CITY OF PORTLAND, MAINE

August 16, 2018

Project Name: **New 8-unit building: 7 residential units and 1 commercial unit condominium**
Project ID: Subdivision and Site Plan: # PLO00030-2018
Address: 28 Vannah Avenue, Portland CBL: 129 FO11 001
Applicant: Vannah White LLC (Thomas Greer)
Planner: Jean Fraser

PLANNING BOARD REPORT PORTLAND, MAINE

Drawing file: Drawings / C2.5 LANDSCAPE.pdf

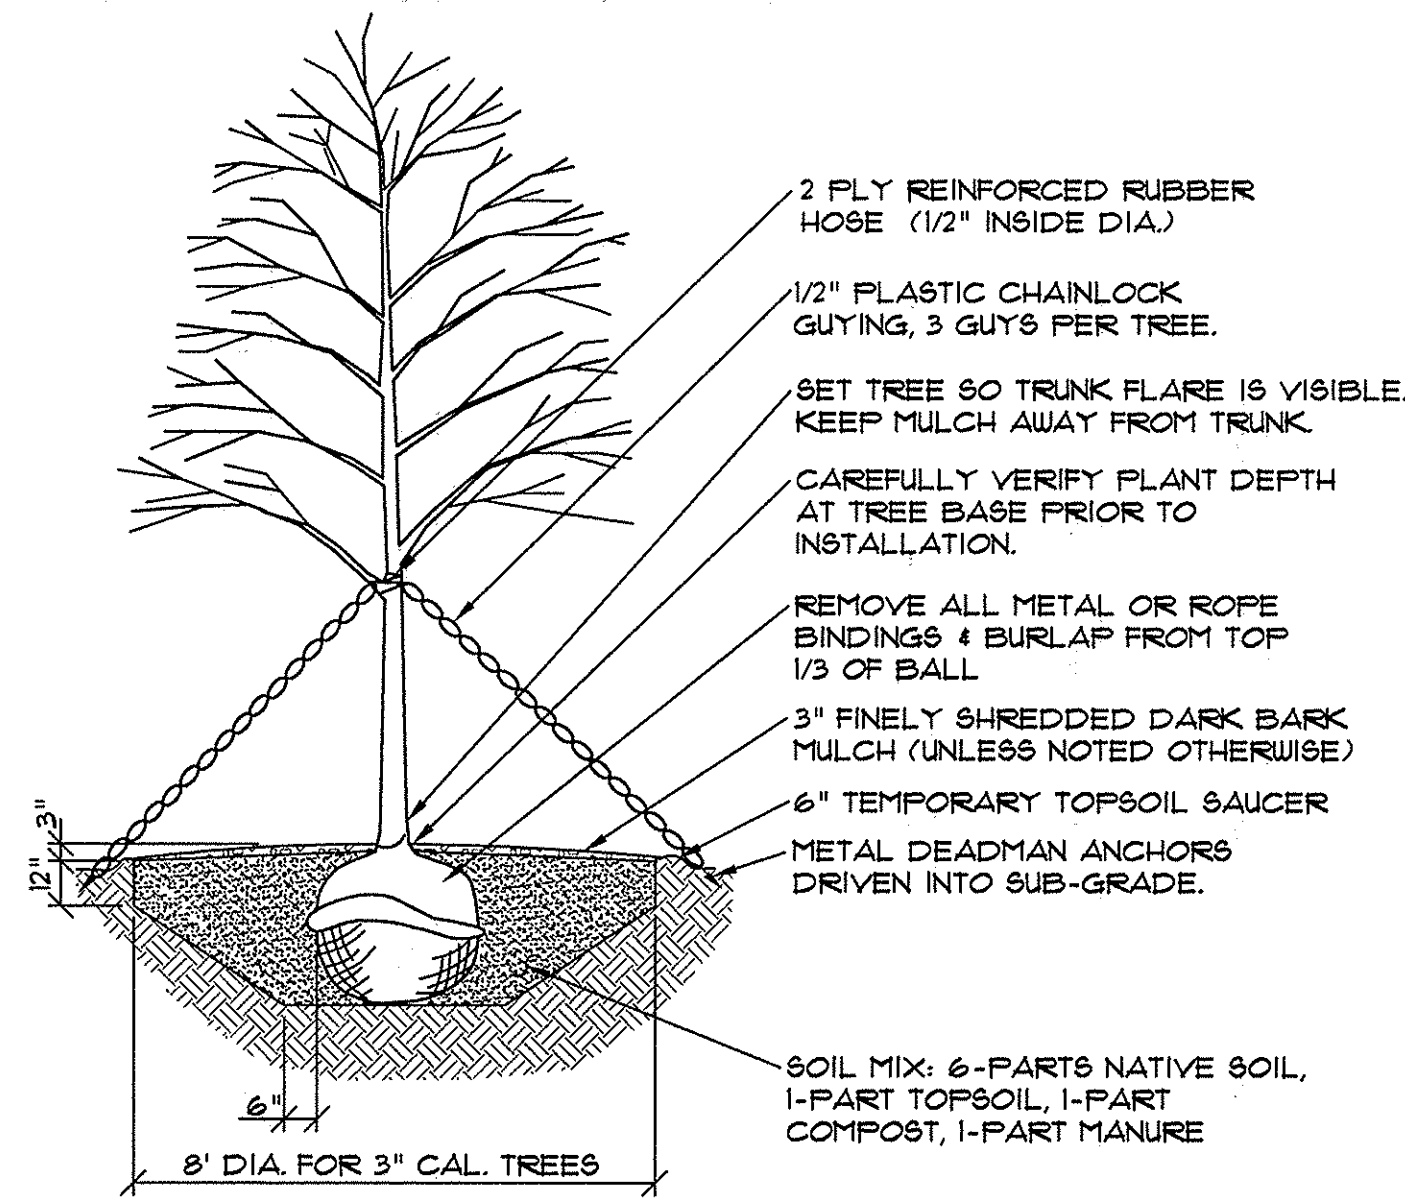
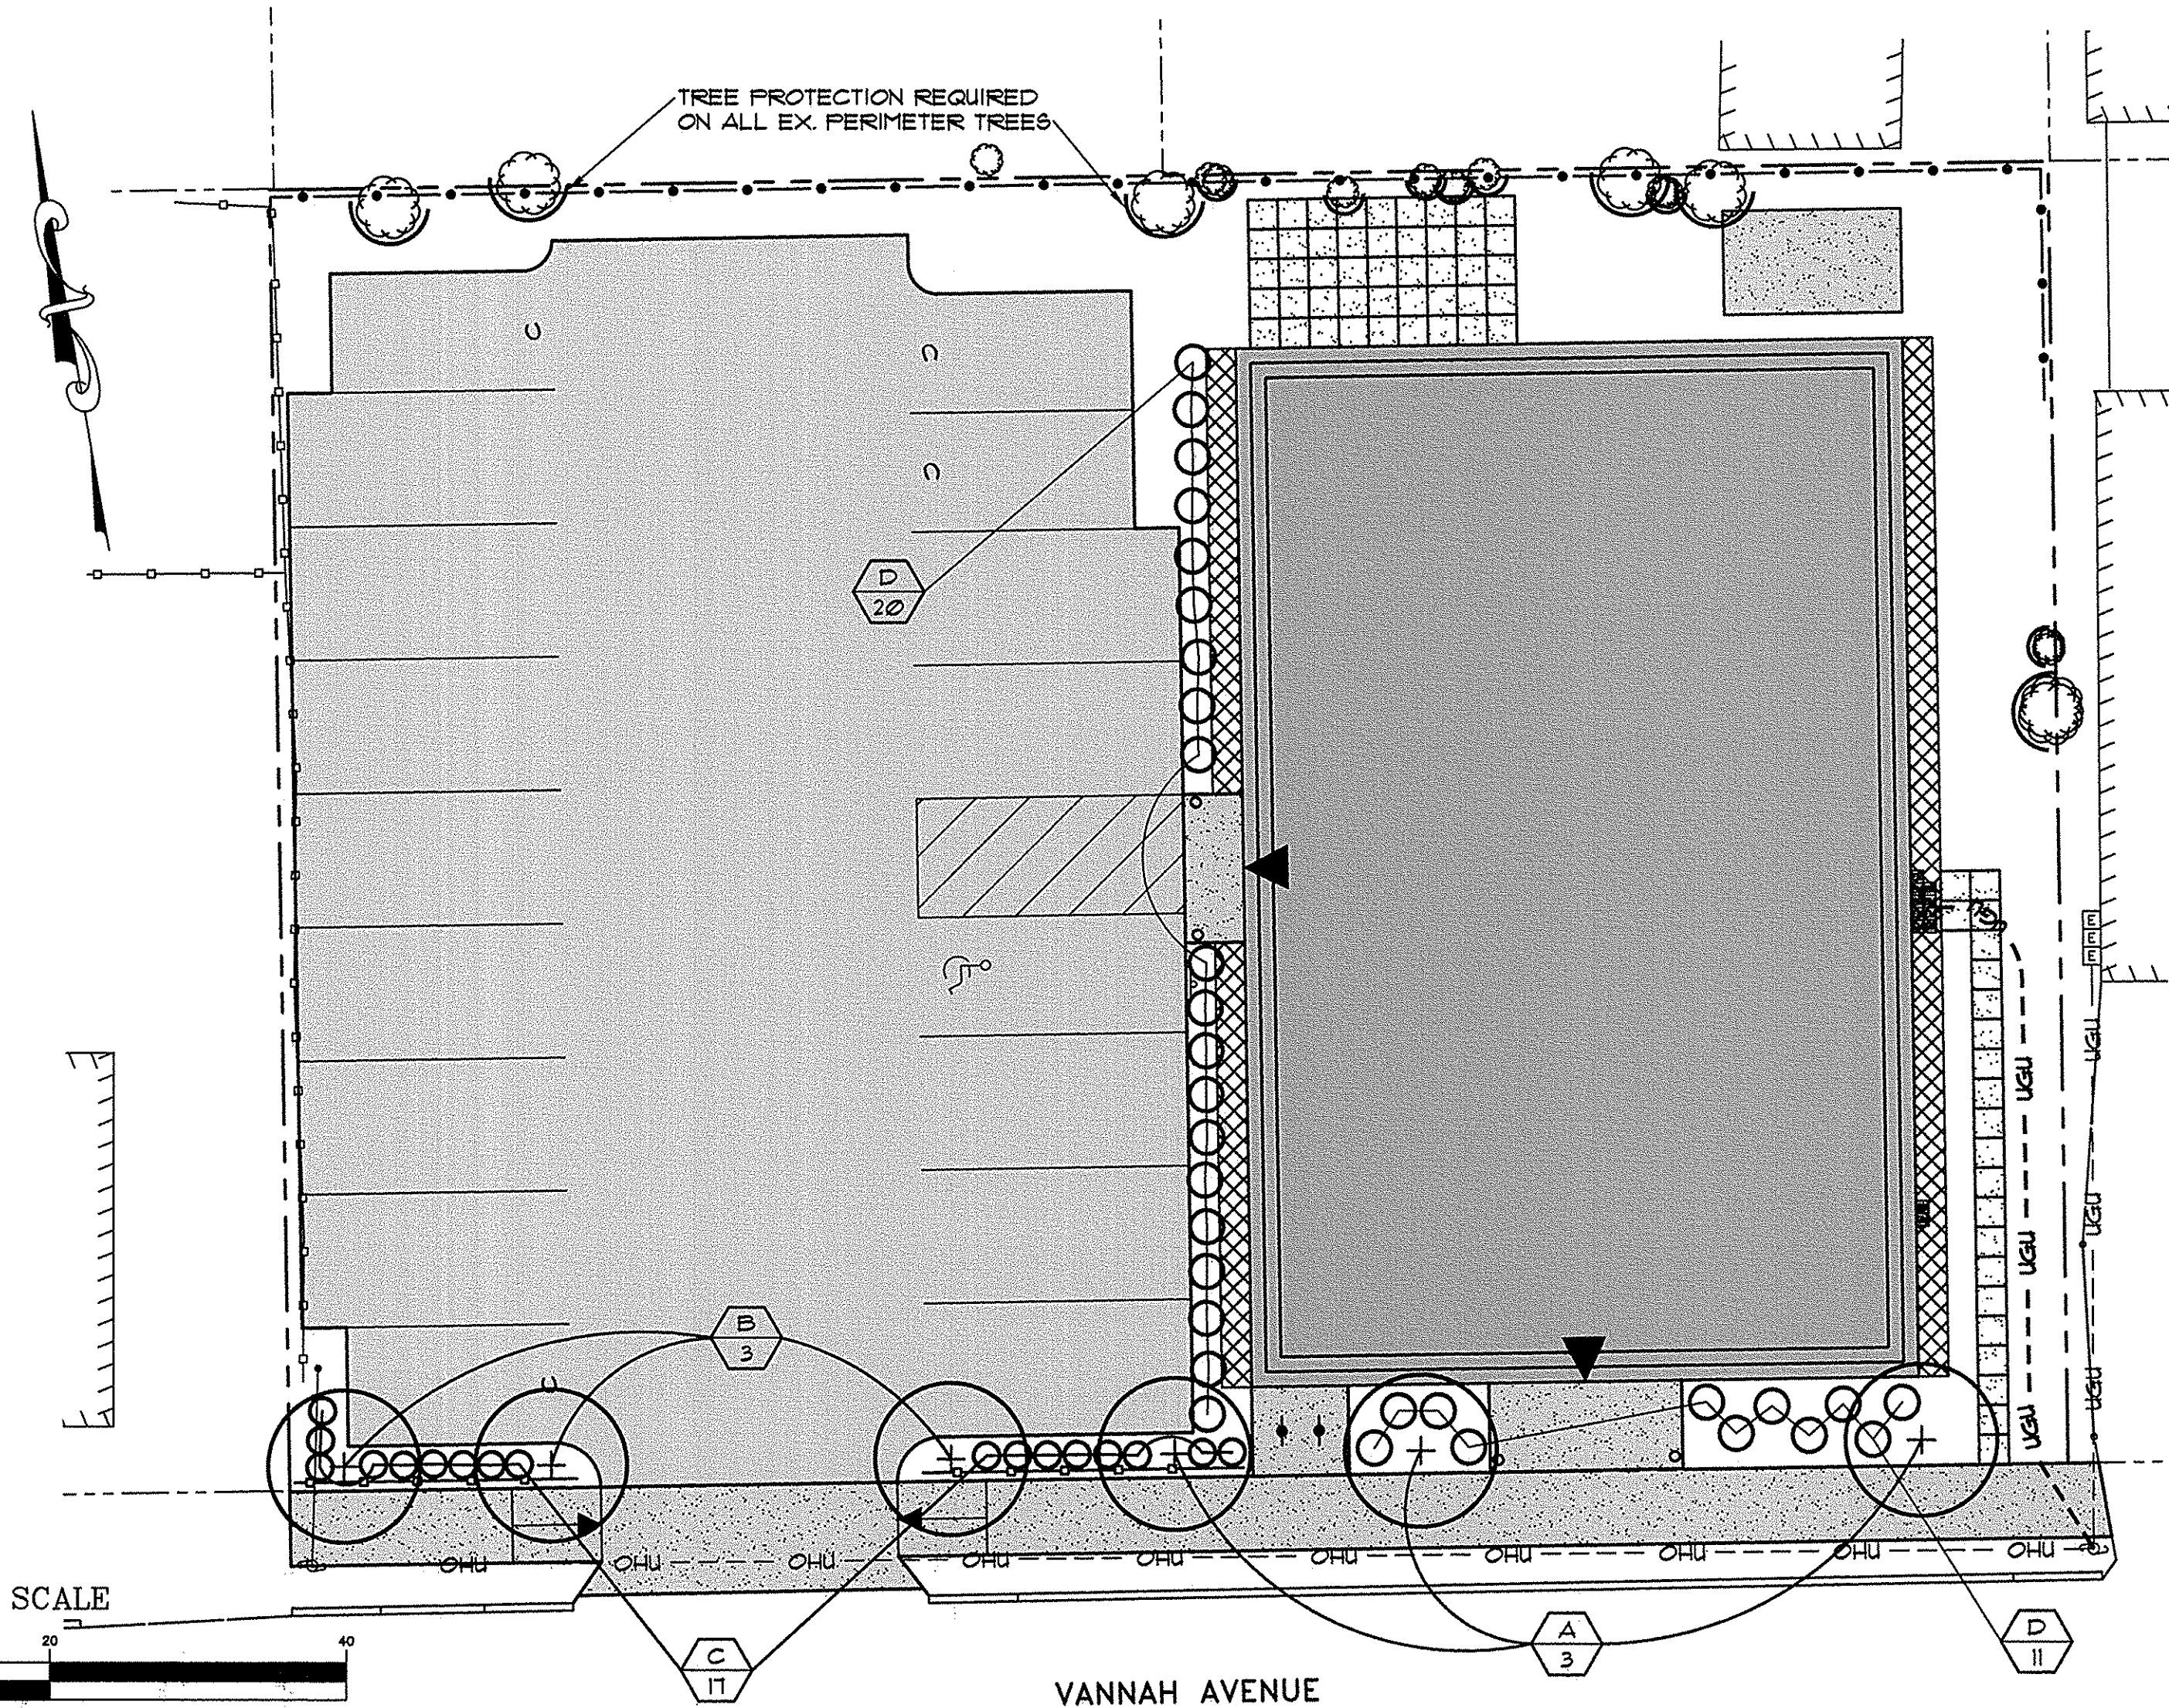
- iv. There are 12 existing trees around the perimeter of the site that are shown to be preserved on the final Landscape Plan. If any of these trees do not survive the impacts of the construction (as determined by the City Arborist one year after the issuance of a CO) then they shall be replaced by the applicant with a similar tree species of 2 inch caliper.
- v. That the applicant has demonstrated that site constraints prevent the planting of all of the 7 required street trees (one per unit for multi-family development) in or near the right-of-way, and therefore the applicant shall contribute \$400 for one street tree to Portland's Tree Fund.
- vi. That the design of the apron and associated sidewalk shall meet Technical Standards and conform to the design detail provided in the final submissions (2% maximum cross-slope).

Jeff Tarling, the City’s Arborist, is generally supportive of the proposed tree preservation and landscaping; he has recommended that a condition be included to require tree replacement if any of the preserved existing trees do not survive the construction impacts (Attachment 5).
